Our Ref: 2023/105859
File No: R/2023/5
Your Ref: SSD 47662959

Royal Prince Alfred Hospital Redevelopment – SSD 47662959 – Advice on EIS

Thank you for your correspondence dated 1 February 2023 inviting the City of Sydney Council (the City) to comment on the proposed redevelopment of Royal Prince Alfred Hospital (RPA).

Tree Management Plan

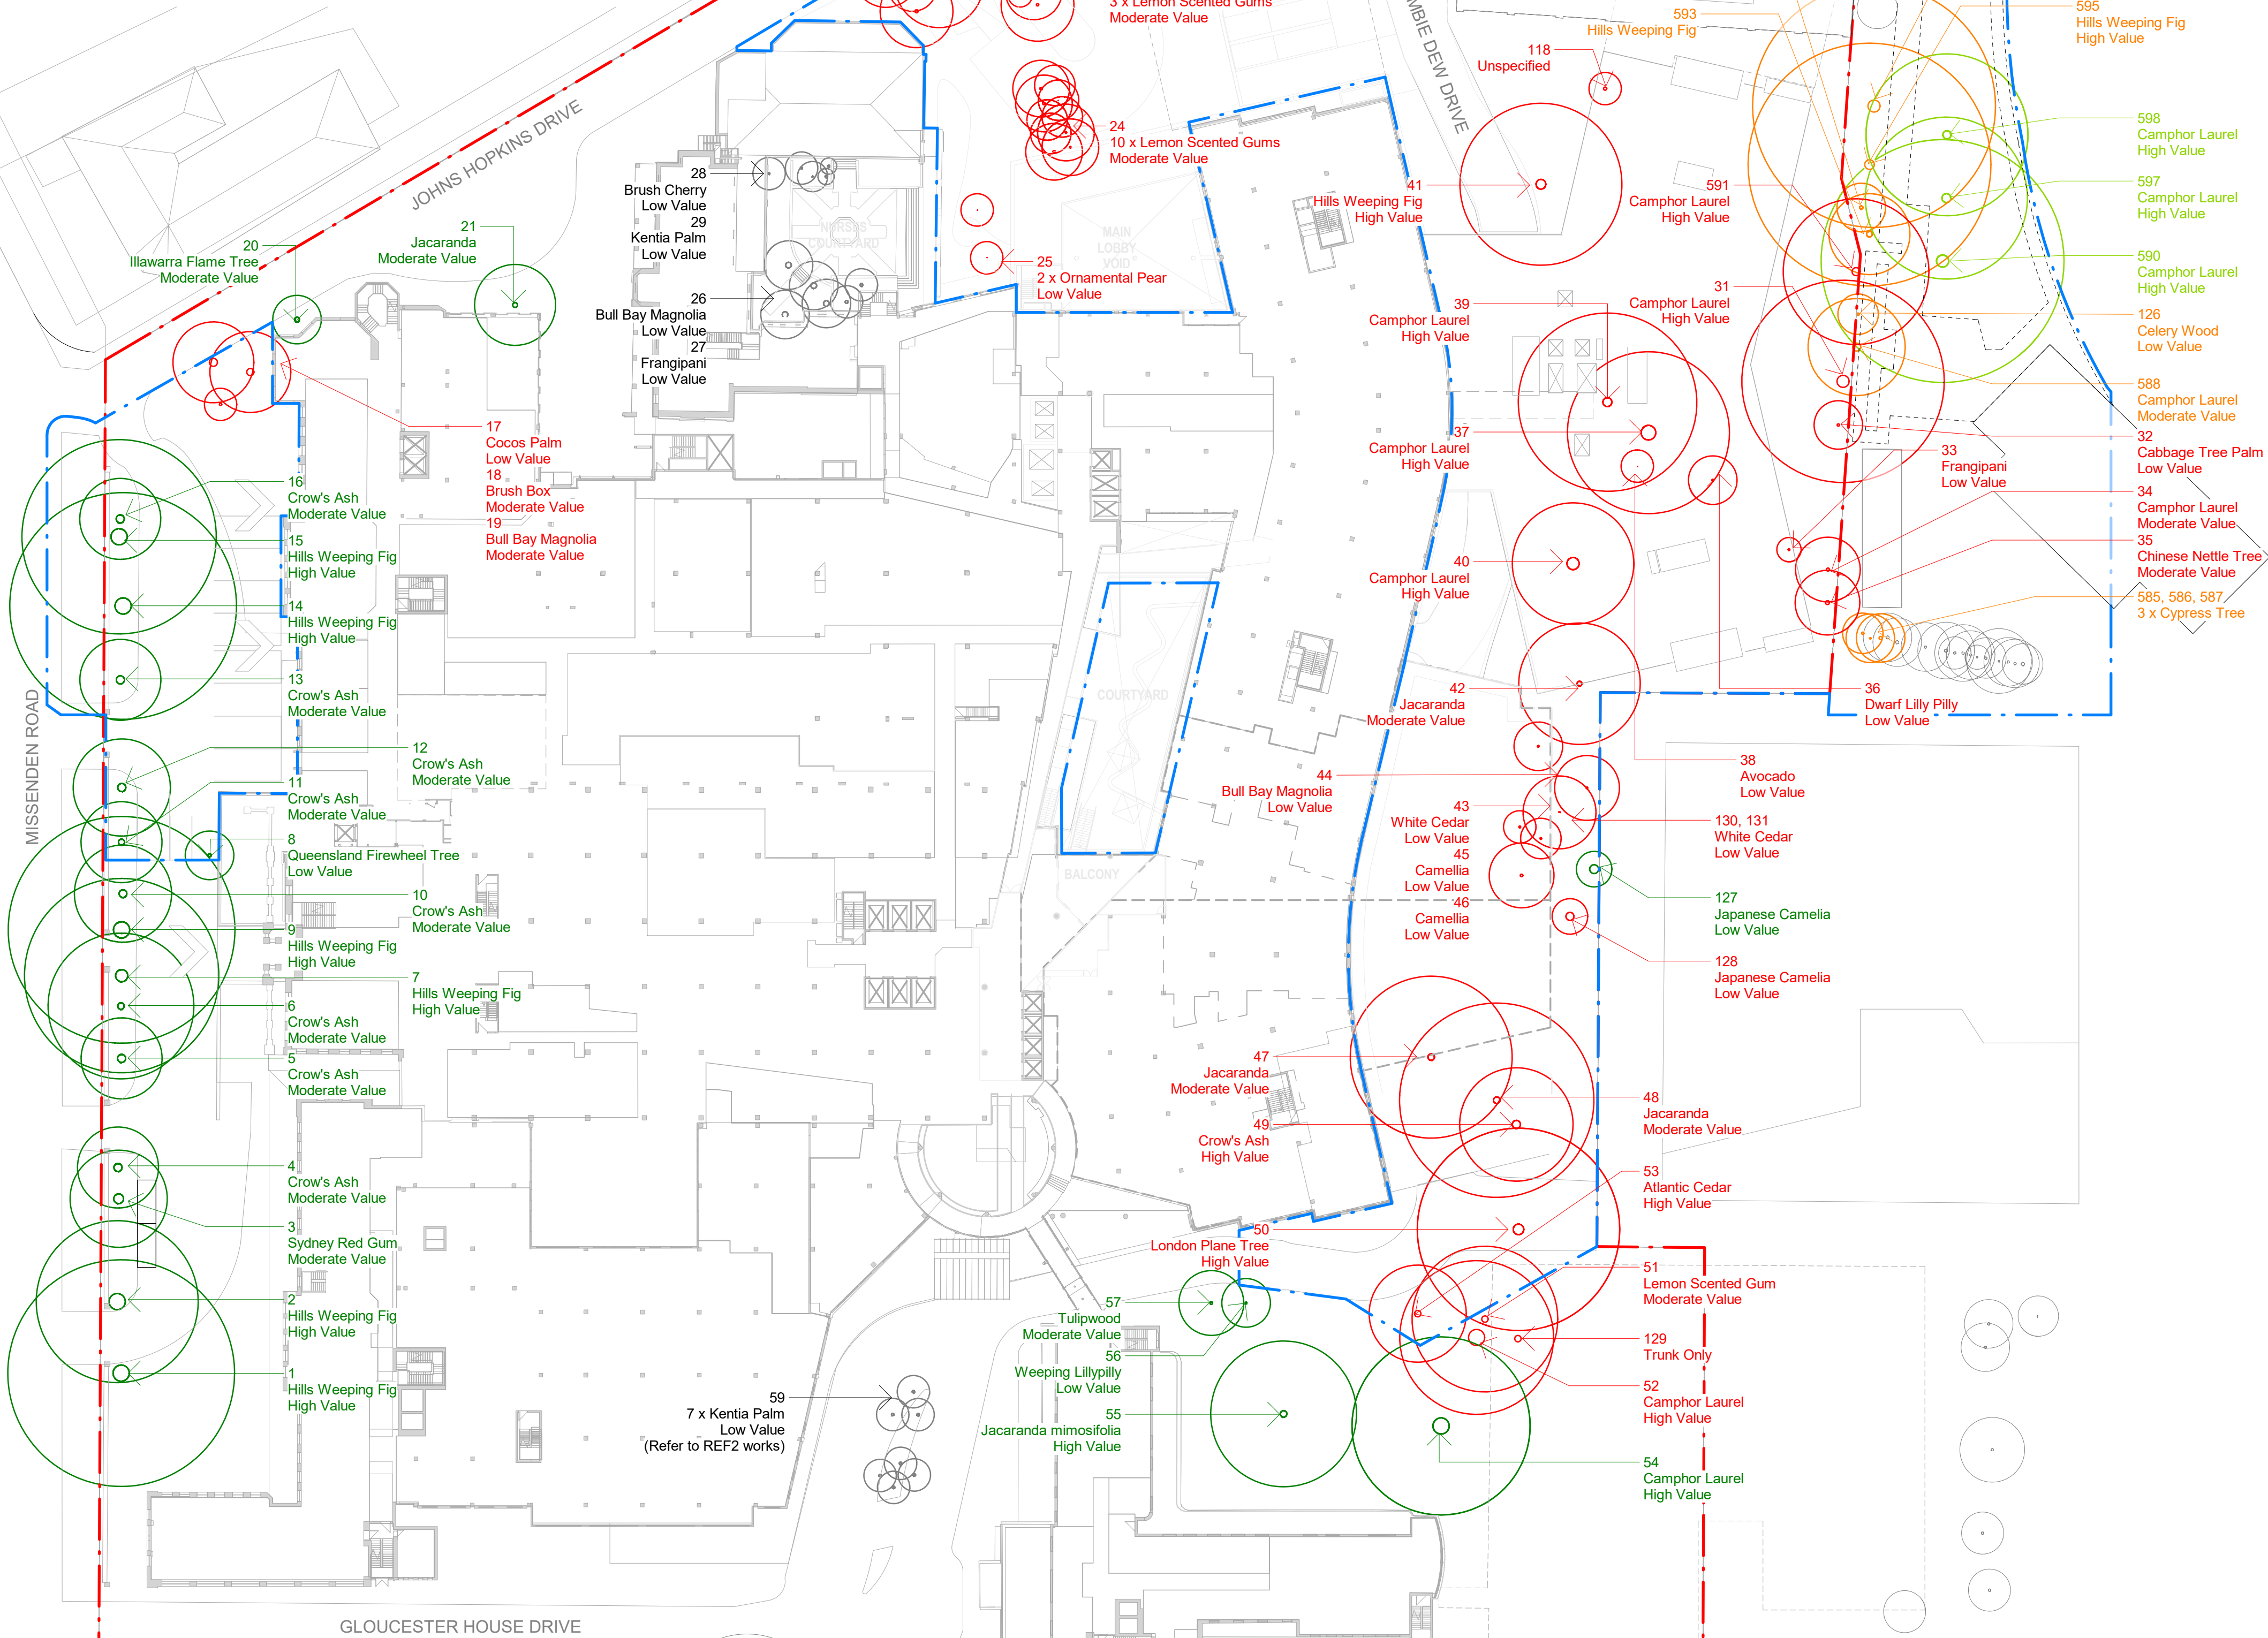
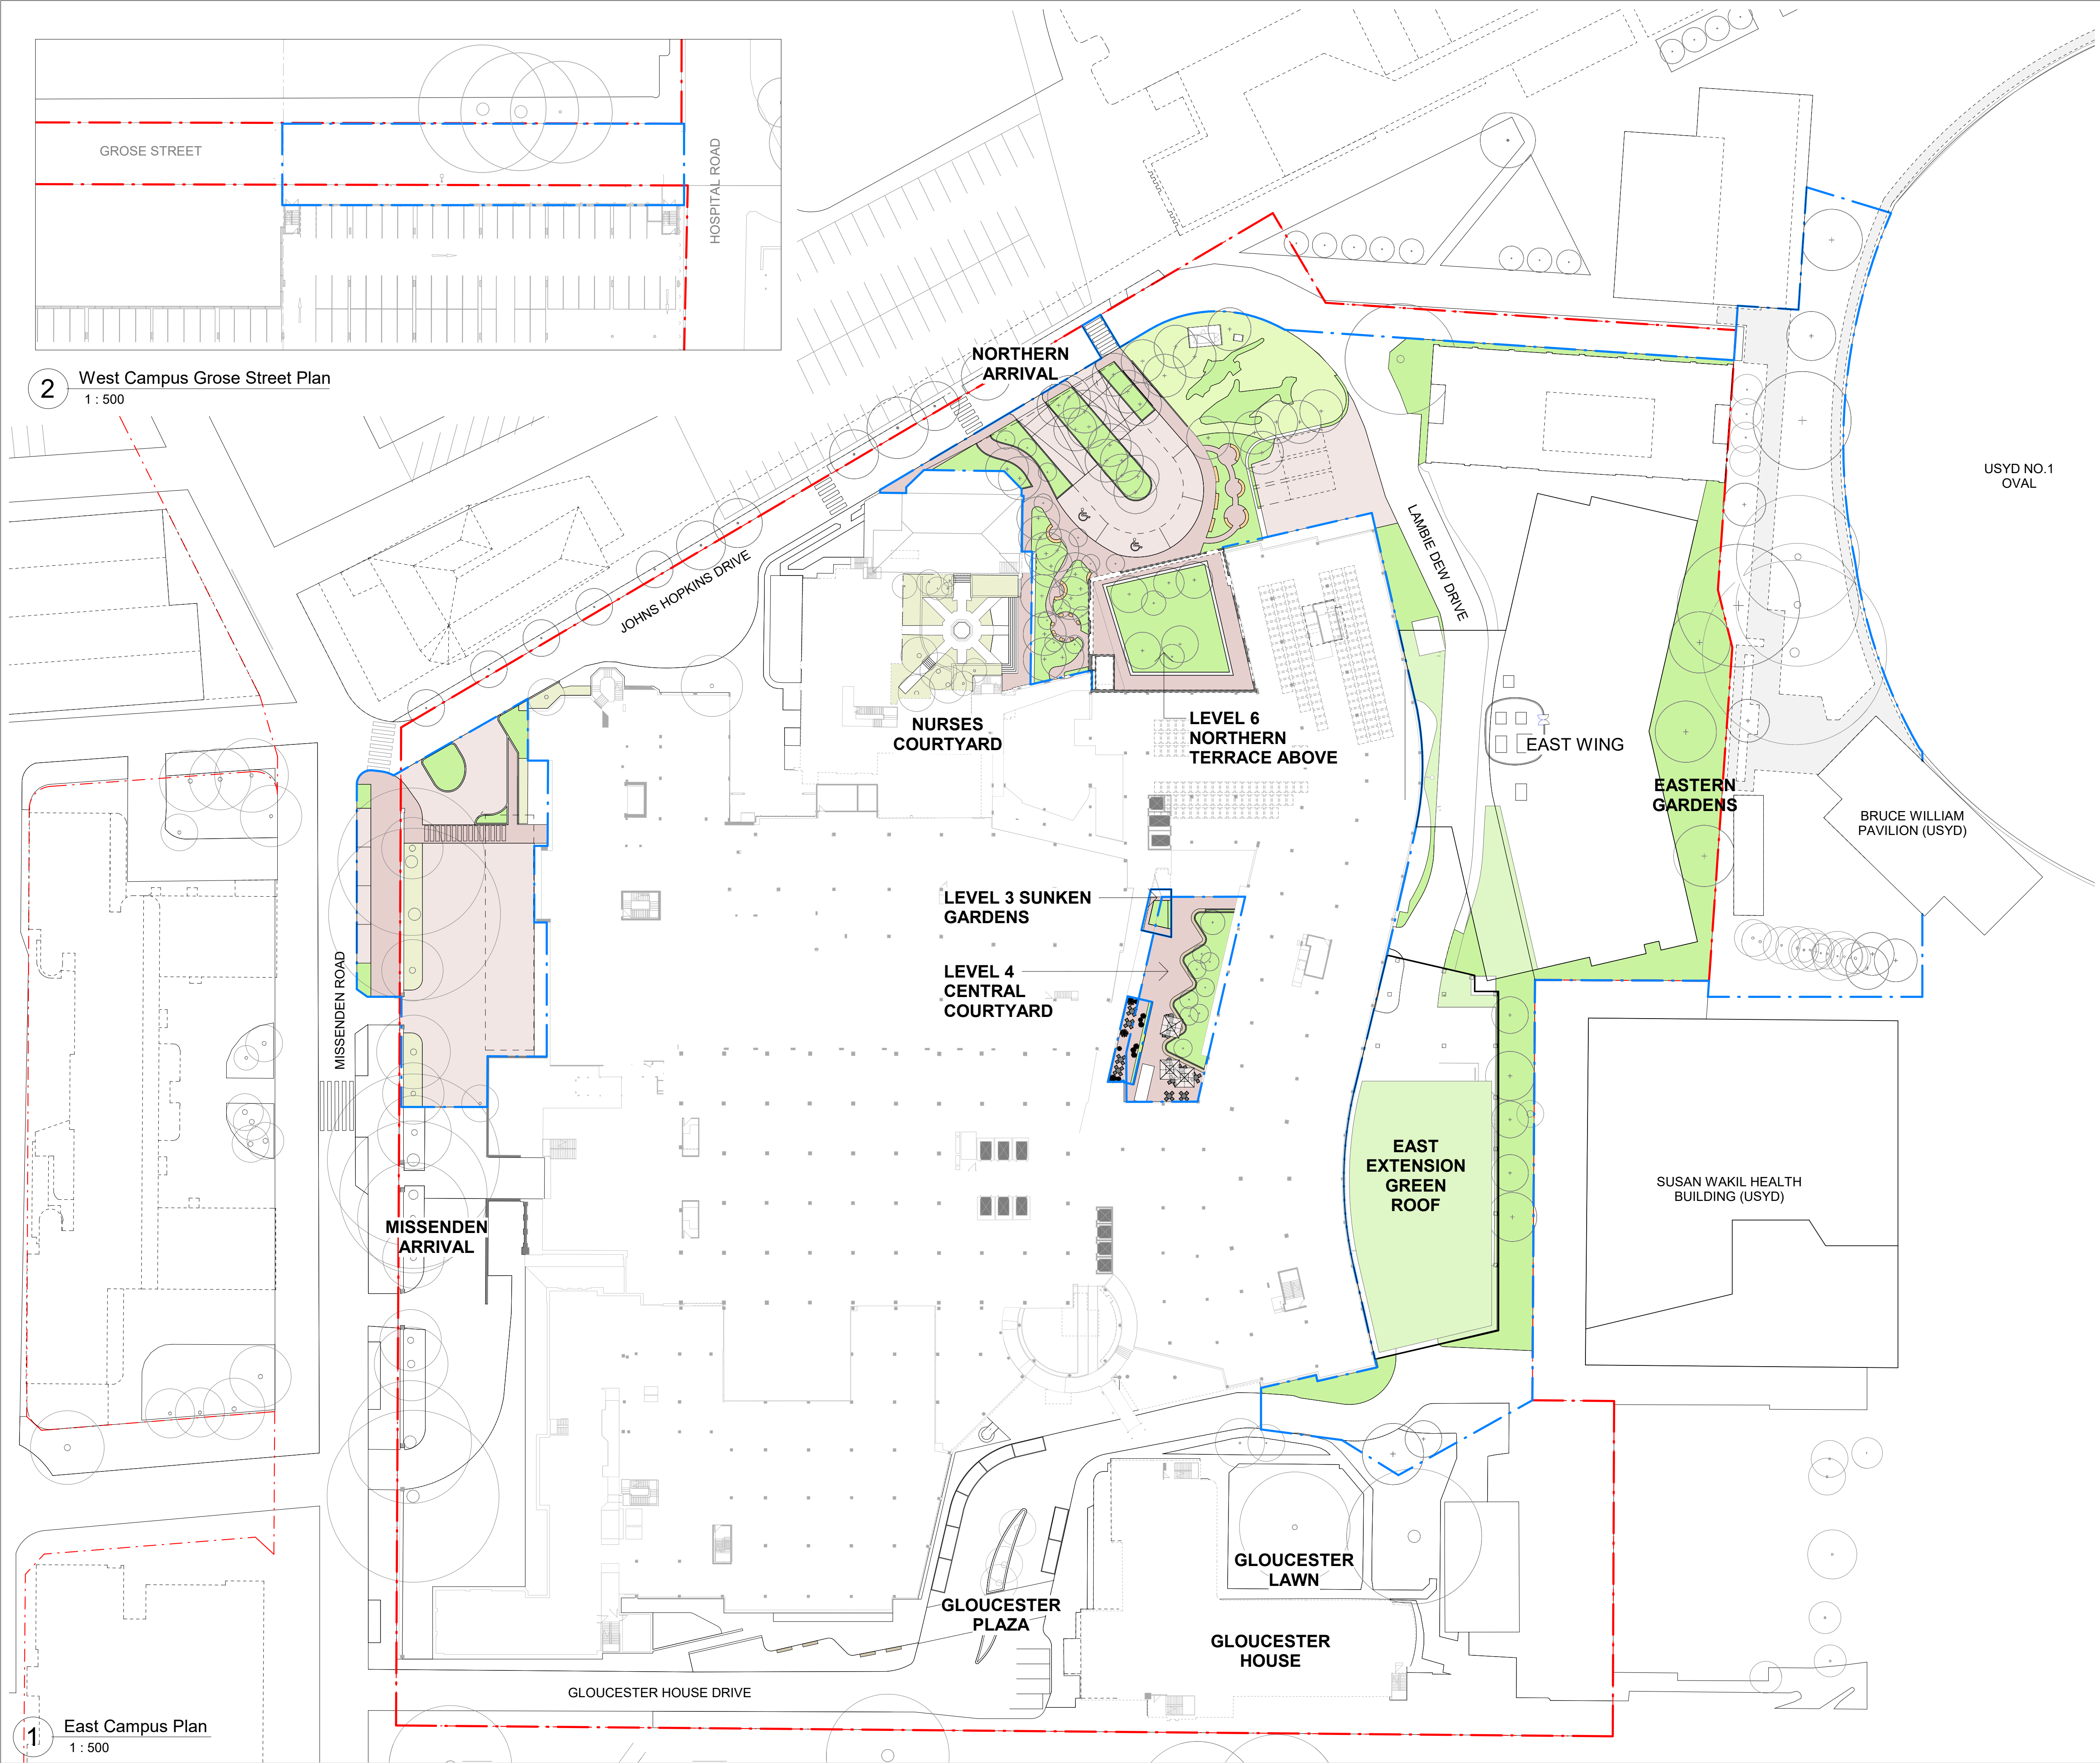
- Amendments to the design are required to indicate the retention of the high and moderate value trees 18, 19, 31, 34, 37, 39, 40, 41, 42, 47, 48, 49, 50, 51, 52, 53, 585-587, 588, 591, 593 and 595 as listed within the table under Tree Removal – Not supported above.
- An Arboricultural Impact Assessment report (stage 2) is required and is to be based on further detailed plans regarding the redevelopment. The report will also need to include a Tree Protection Specification detailing specific, tree protection measures and tree sensitive construction methods which will be utilised to minimise the impact of the works upon existing trees. The report should adhere to the recommendations outlined in Section 5.2 – 5.6 of the AIA report by Martin Peacock dated 14/11/2022.
